DECISION DELEGATED TO HEAD OF PLANNING

Application No: H15-0951-21 **Applicant:** M Collier-Brown

Proposal: Demolish existing extension & replace with kitchen extension - re-submission of H15-0240-21

Location: The Cottage Beck Bank Quadring Fen

Drawing Title	PROPOSED PLANS AND ELEVATIONS	Drawing number	DC / 603C / 70
Scale	1:100, 1:50	Drawn	db
Date	FEB 2021	Checked	REV F

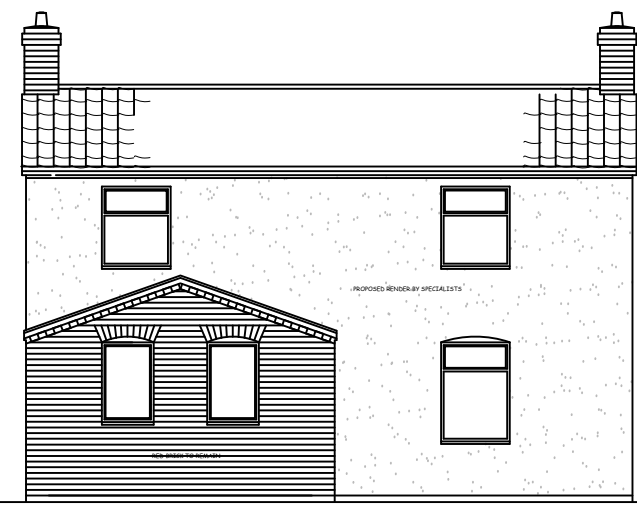
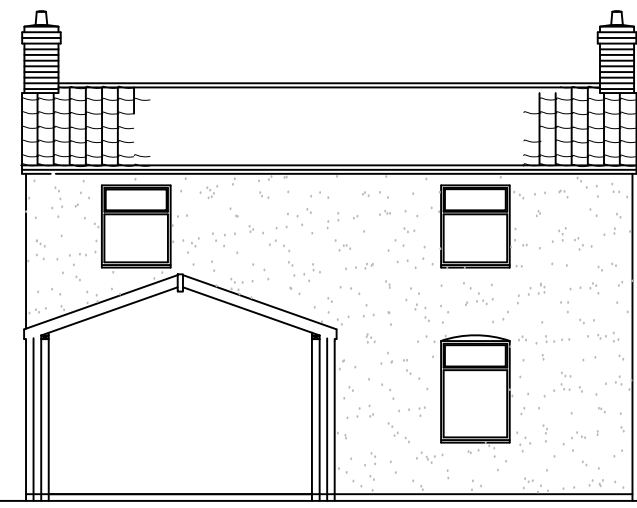
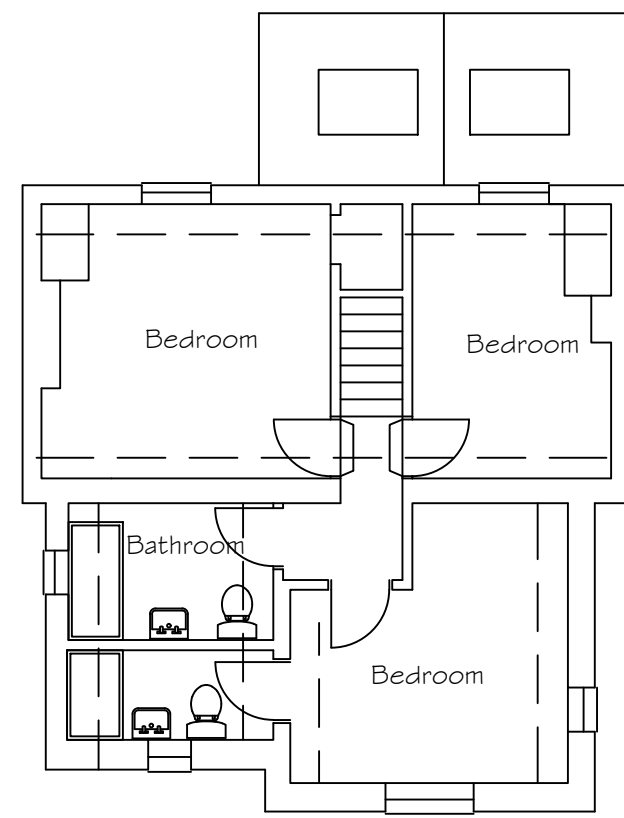
This is a full application at The Cottage, Beck Bank, Quadring Fen to demolish an existing extension & replace with kitchen extension - re-submission of H15-0240-21. The proposal seeks to provide a kitchen extension that projects 2.3 metres from the existing kitchen and measures 4.894 metres in width. The eaves height will be approx. 2.1 metres and the ridge height 3.1 metres. Brick and tile of

the kitchen extension is to match that of the existing dwelling and would be conditioned as such. This application also seeks to render the original, central part of the dwelling at ground and first floor level. The proposed render colour is off white.

To completely render would be out of keeping - N.B. The central, original dwelling is to be off white rendered. The extended elements will remain in red brick.

2. The design is considered to be appropriate for the site and is subservient in scale to the main dwelling. The current porch entrance projects 1.2 metres from the existing wall and is of a similar

height, so it is not considered that the proposed design will materially alter the appearance of the building. There are other rendered properties in the vicinity and this will help to extend the lifetime of the existing brick and thereby improve the overall appearance.

3. Brick and tile is to match that of the existing dwelling and would be conditioned as such. The proposed render colour is off white and is considered to be an appropriate colour for the dwelling and the character of the surrounding area.
